# SPR EA1N and EA2 PROJECTS

## DEADLINE 6 - SASES COMMENTS ON ExQs2

Interested Party: SASES

Date: 24 February 2021

**Figure: 29.37f**  
**Viewpoint 5: Public Right of Way, near Moor Farm**

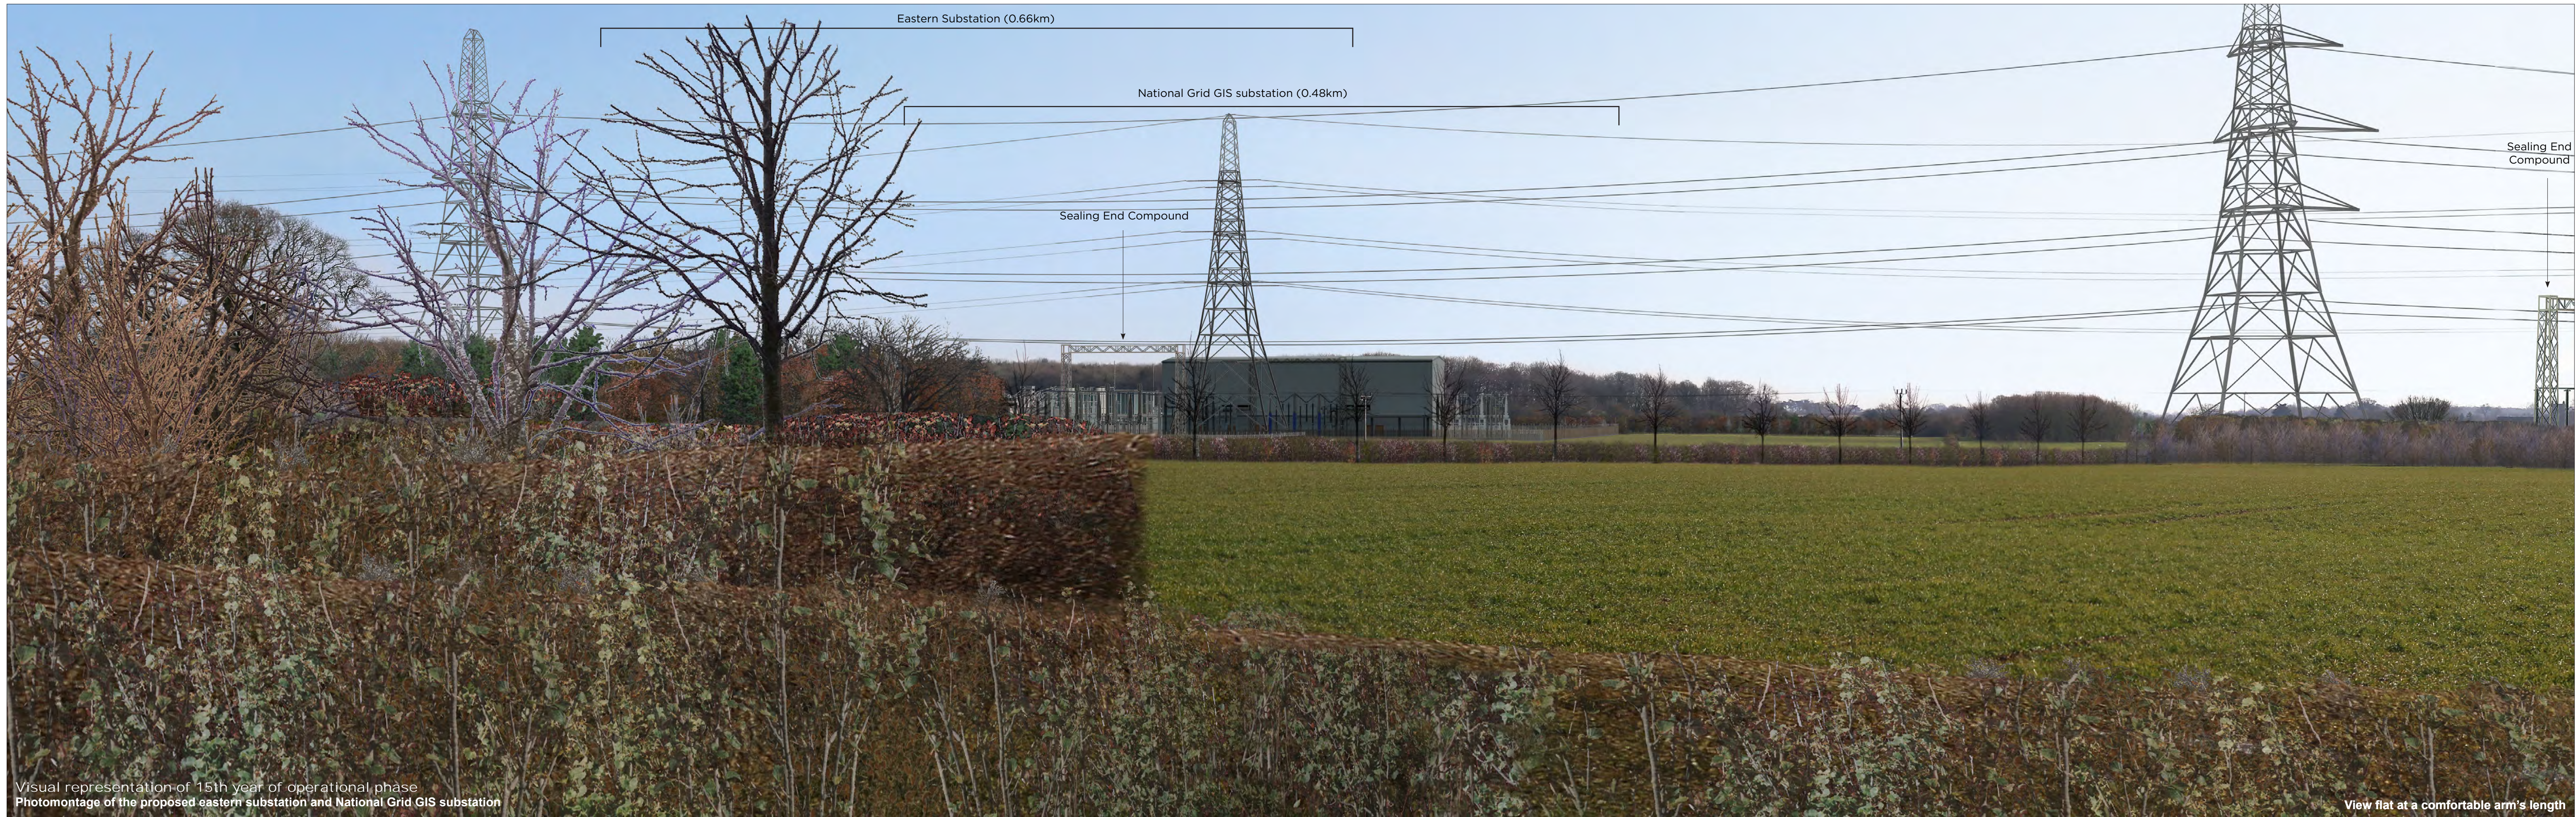
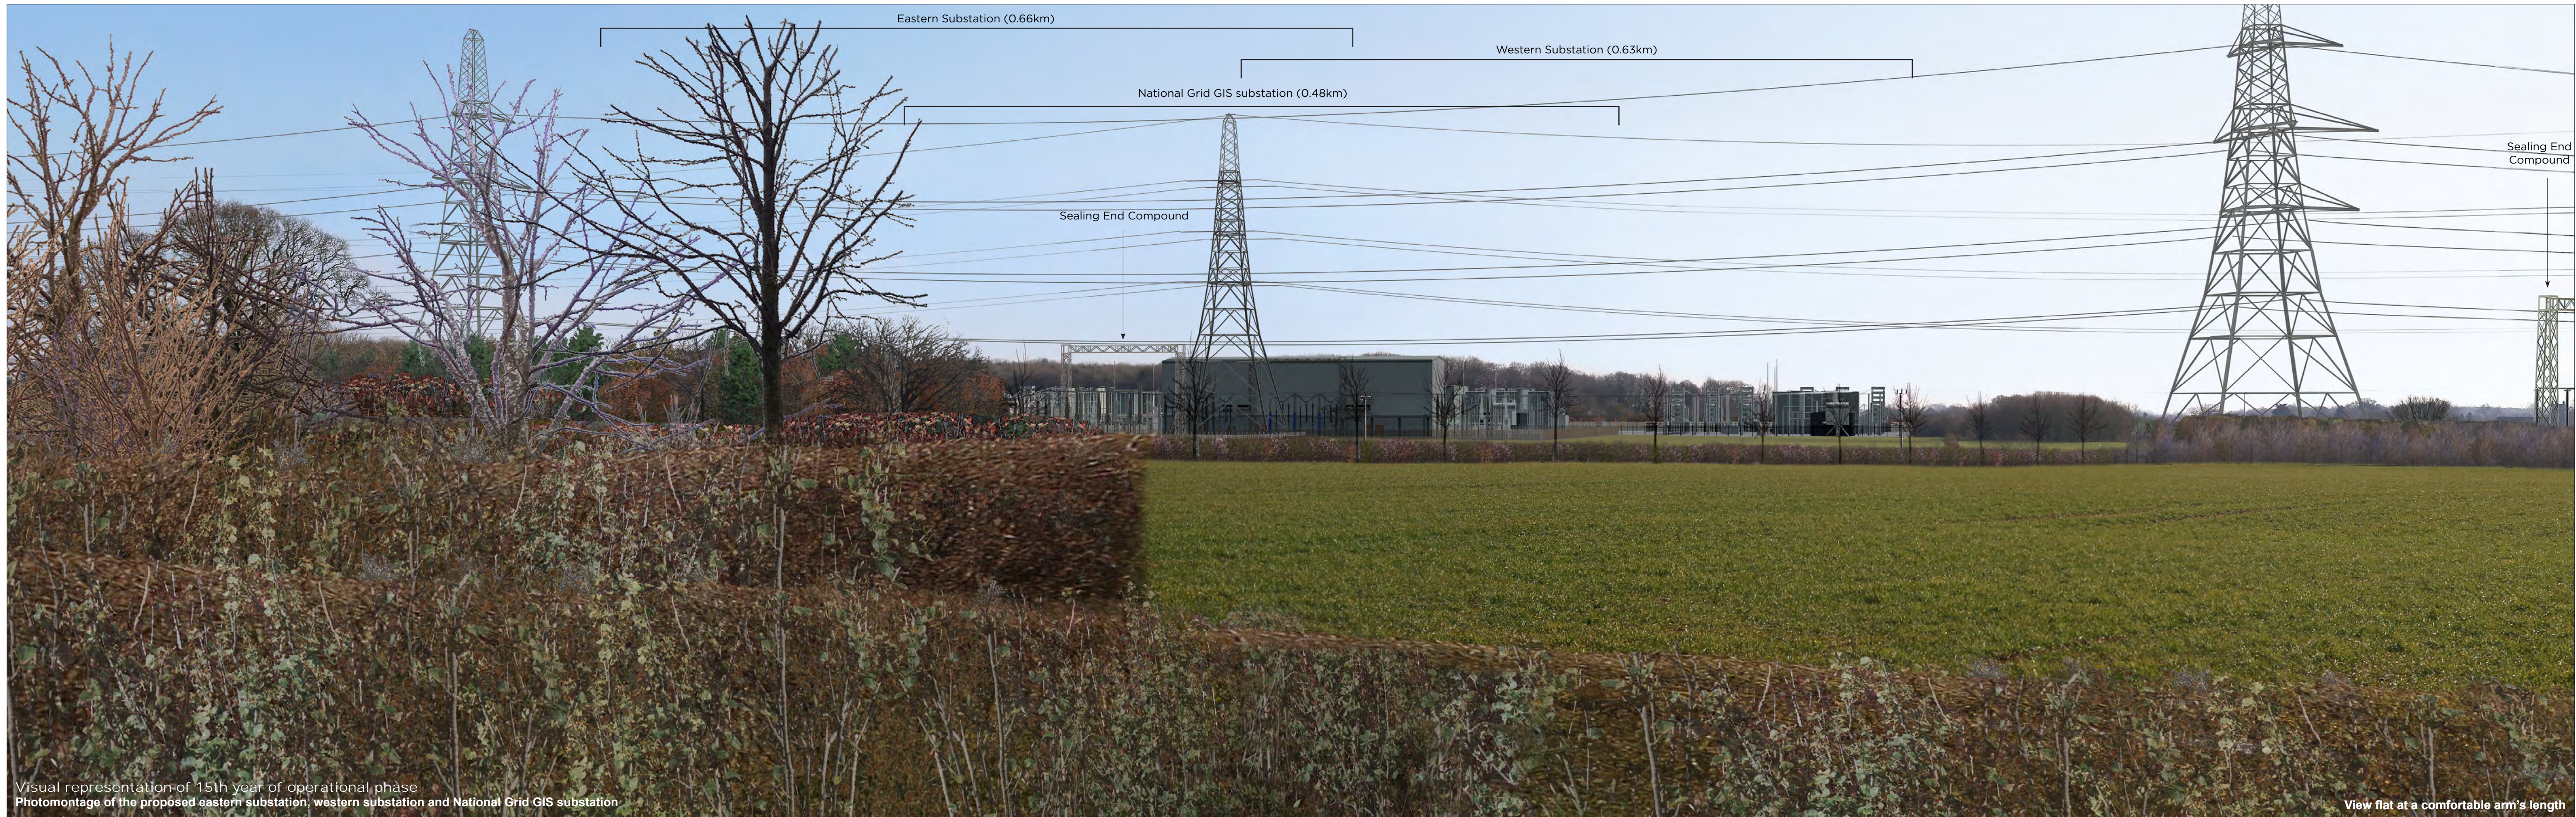
2.10.7	Proposed sealing end compounds	<p>Vp 5 is representative of views from the PRow but it is also located close to the listed Friston Moor Farmhouse and within its agricultural setting.</p> <p>Visible from Vp 5 is the highest item of equipment within the cable sealing end compounds, the overhead line gantry at 16m above finished ground level.(ES Project description paragraph 517). There has been no reduction in this height. There is no mention of the sealing end overhead line gantry in</p>

<p>Table 4.2 of the Onshore Substations Update Clarification Note (REP3-057). It is now the highest piece of equipment within all the substations excepting the lightning protection masts (20m) which are slender structures in comparison. It would be helpful if all the heights of all the pieces of equipment and the AOD heights could be listed in the Substations Design Principles Statement lists showing where reductions have been made. See also SASSES' post ISH9 submission in respect of Requirement 12.</p> <p>The sealing end with circuit breaker compound is about 250m from Vp 5. The two other sealing end compounds are both within 500m. The additional pylon is also located close to the sealing end with circuit breaker compound and within approximately 250m of Vp 5. The relocated pylon is located closer to the Vp 5 than the existing pylons. Behind these substantial structures, equipment within the National Grid substation and the western substation is visible. The range, the scale and the extent of the equipment is evident due to its proximity to Vp 5. It is made more evident in the photomontage because there is a comparison with the mitigation planting. Even shown at the highly optimistic heights used by the Appellants' it is dwarfed by the scale and height of the equipment. This is how the equipment will appear in reality. It will dwarf the human scale features and characteristics of the landscape.</p> <p>It is very noticeable when comparing the existing images with the photomontages how the pylons have become more dominant from this location. This is partly due to the fact that they are now closer to Vp; 5 but also because they are now viewed within an industrial complex. Previously they were located within a rural agricultural landscape which could be seen to flow beneath them. From this viewpoint 5 pylons are now seen set within and connected by a substation landscape.</p> <p>The additional planting is not successful in providing additional screening but there are no further measures that could be taken to more adequately screen the sealing end compounds without causing other harm. Elsewhere within the scheme views of this scale have been 'mitigated' by woodland planting that has obscured views by enclosing the viewpoint (e.g. Vp 1). SASSES has always argued that this has its own adverse impacts and does not reduce the impact to negligible, as claimed by the Applicants. This is because the existing views, which are open, characteristic and allow an appreciation of the landscape setting of Friston, will be lost entirely if the planting is as successful as the Applicants' claim. A similar approach has not been adopted at Vp 5 because it is recognised that enclosing the historic farmhouses in woodland would result in a loss of their agricultural setting. In this location it is recognised, and SASSES would agree, that mitigation planting would have adverse impacts that would outweigh the benefits of screening.</p>
